PLANNING COMMISSION STAFF REPORT

TO: Kittitas County Planning Commission
FROM: Mackenzie Moynihan, Staff Planner
DATE: June 16, 2008 for June 24, 2008 public meeting
SUBJECT: Schmaus #4 Preliminary Plat (P-07-55)

Proposal: Schmaus #4 Preliminary Plat (P-07-55)

**SCHMAUS No. 4 PLAT**  
PTN. SW1/4 OF SECTION 21, T.20N., R.14E., W.M.  
KITITAS COUNTY, STATE OF WASHINGTON

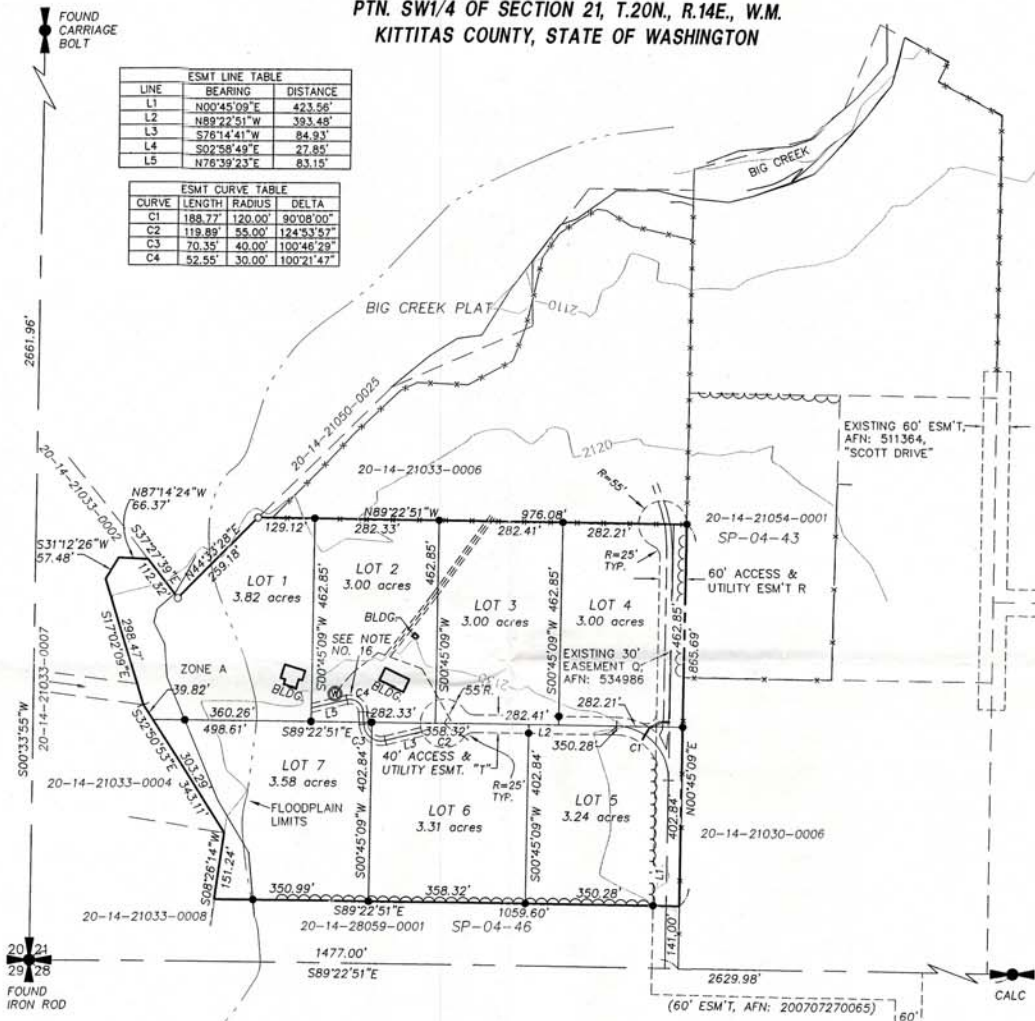
Transportation: The proposed access to the plat will be by an existing easement on the east edge of the property (easement "Q") and a proposed access and utility easement (easement "T") from the intersection of easement "Q" westward through the center of the plat to end in a cul-de-sac and serve all lots. Both easements shall be constructed to be 60' wide.

7. The applicant shall meet or exceed all rules and regulations set forth from the Department of Public Works as included in the issued memorandum.
8. Big Creek shall be shown on the face of the final mylars and its associated floodplain shall also be depicted.
9. A plat note shall be added to the final mylars that states the following:
